HILL SUBDIVISION FILING NO. 1

A REPLAT OF LOT 1, C AND H ESTATES

MINOR SUBDIVISION PLAT
HILL SUBDIVISION FILING NO. 1

MVE PROJECT: 61174
MVE DRAWING: 61174-PLAT-CS
DATE: APRIL 26, 2023
SHEET: 1 OF 2

HILL SUBDIVISION FILING NO. 1

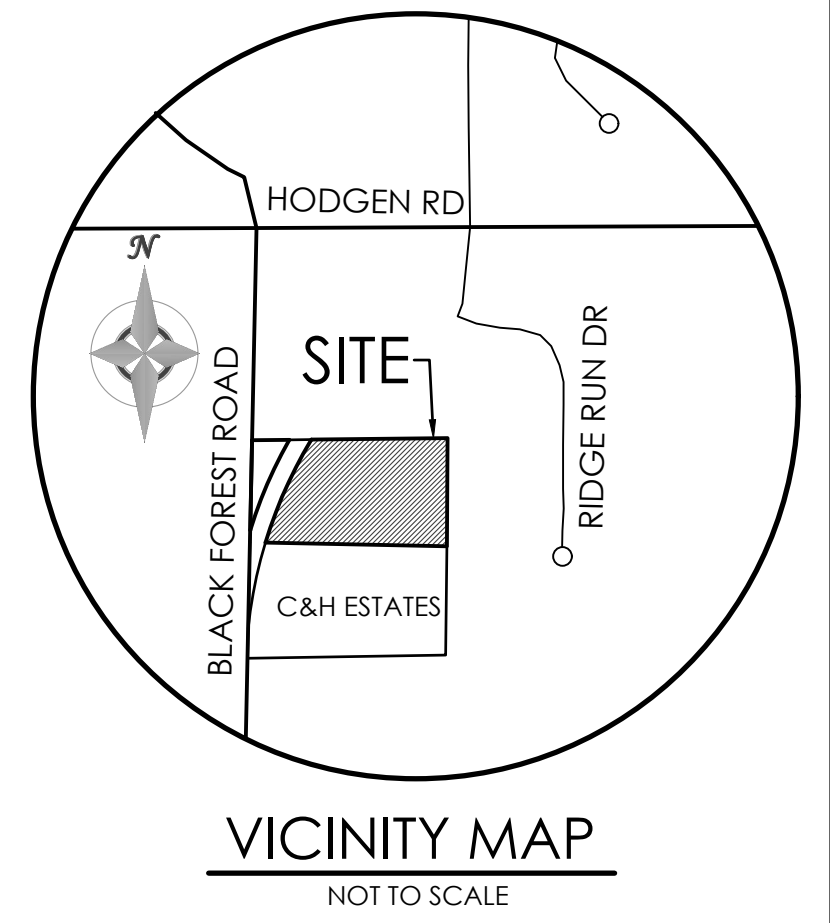
Include the section and quarter section in the title block.

Add the following information:

Name, address and telephone number of the owner of record located in the lower right hand corner,

Date of preparation, date of survey (if applicable), north arrow, written and graphic scale located in the lower right hand corner of each sheet,

Names, address, and telephone number of person(s) responsible for preparing the plat (e.g., licensed surveyor, licensed engineer or designer of the plat) located in the lower right hand corner (if applicable),

Date of submission with provisions for dating revisions located in the lower right hand corner

Add PCD File No. VR2313

"AS PLATTED"
(PLAT NO. 12276)

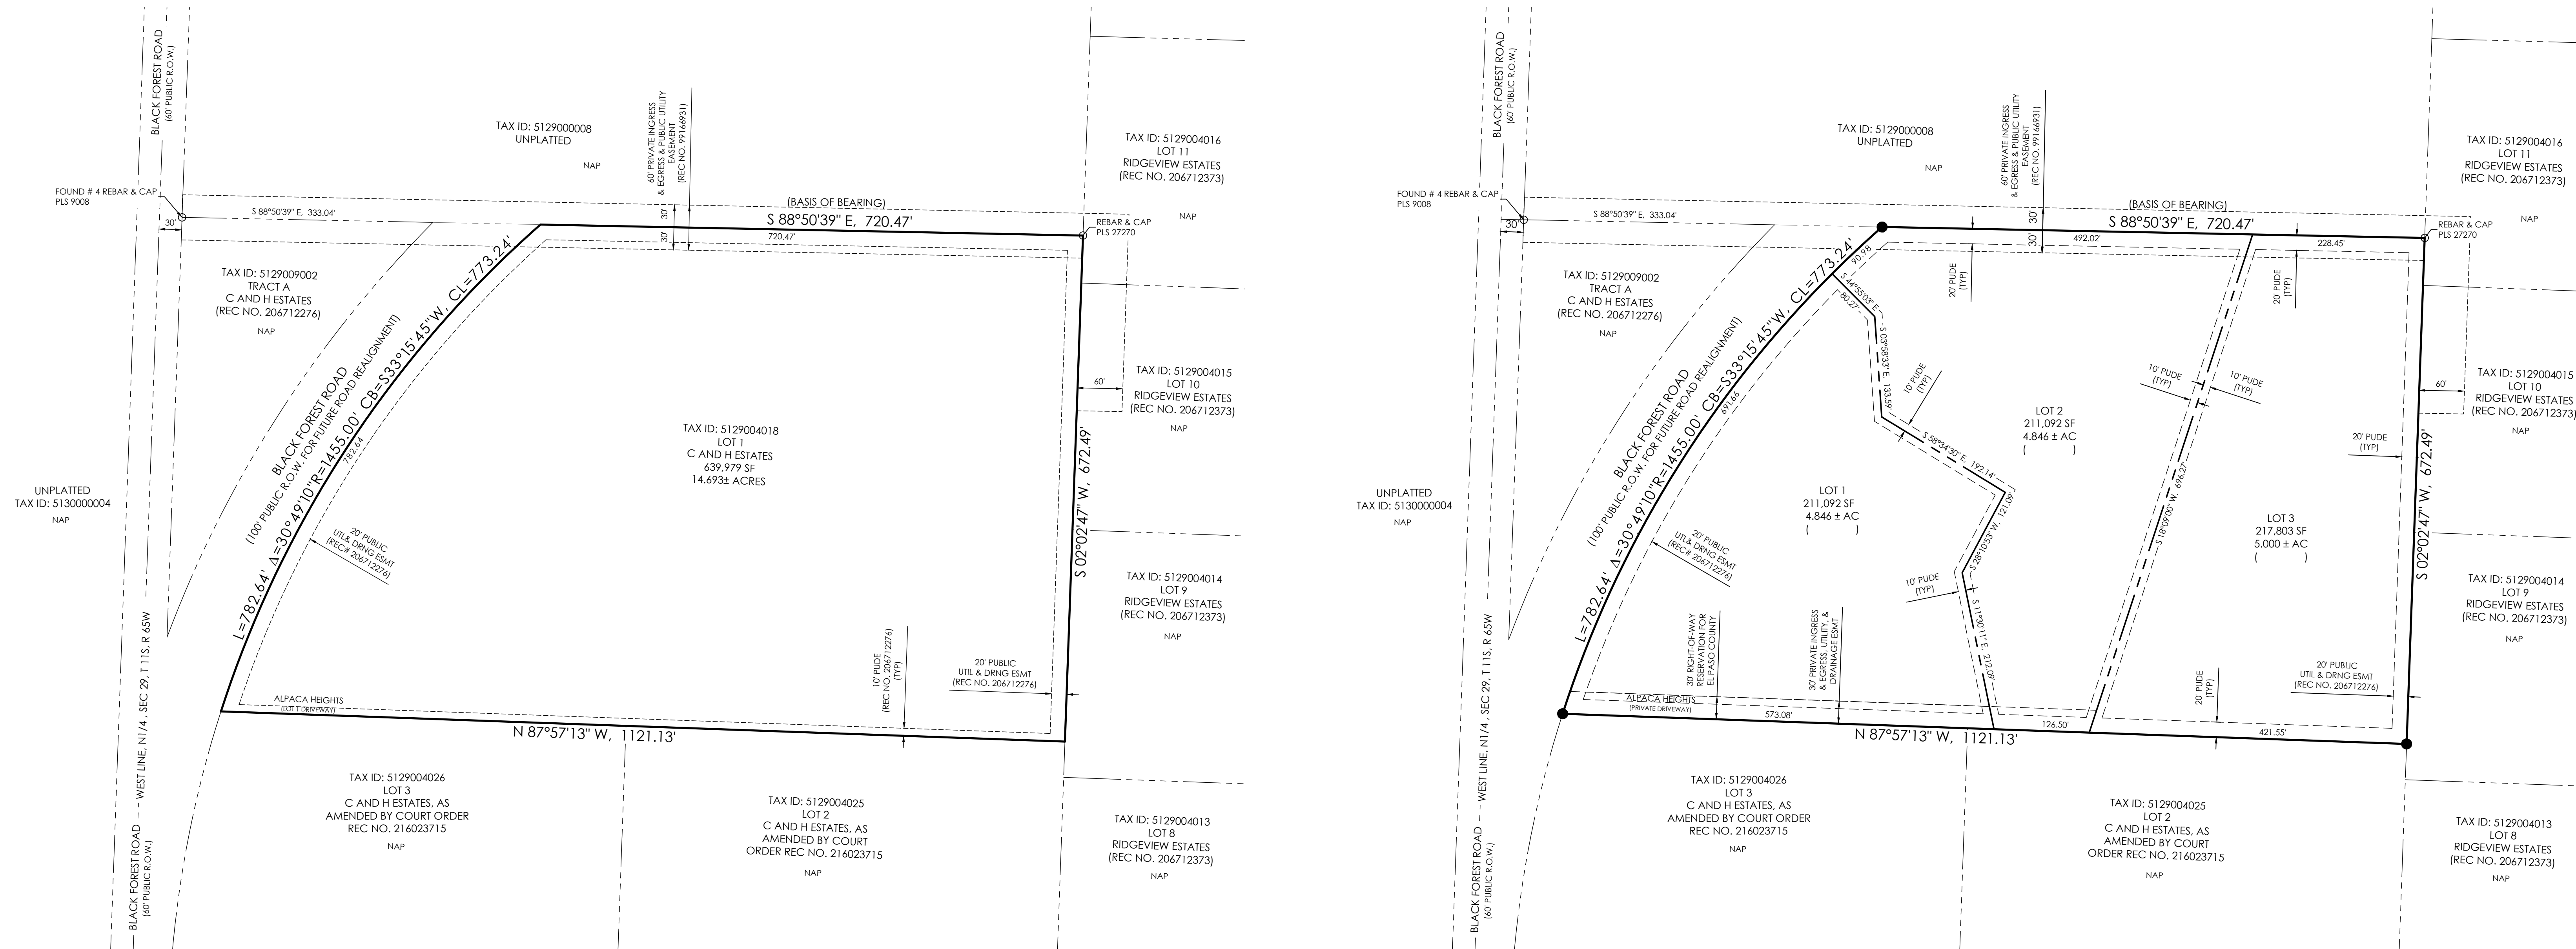
Add current plat #12276
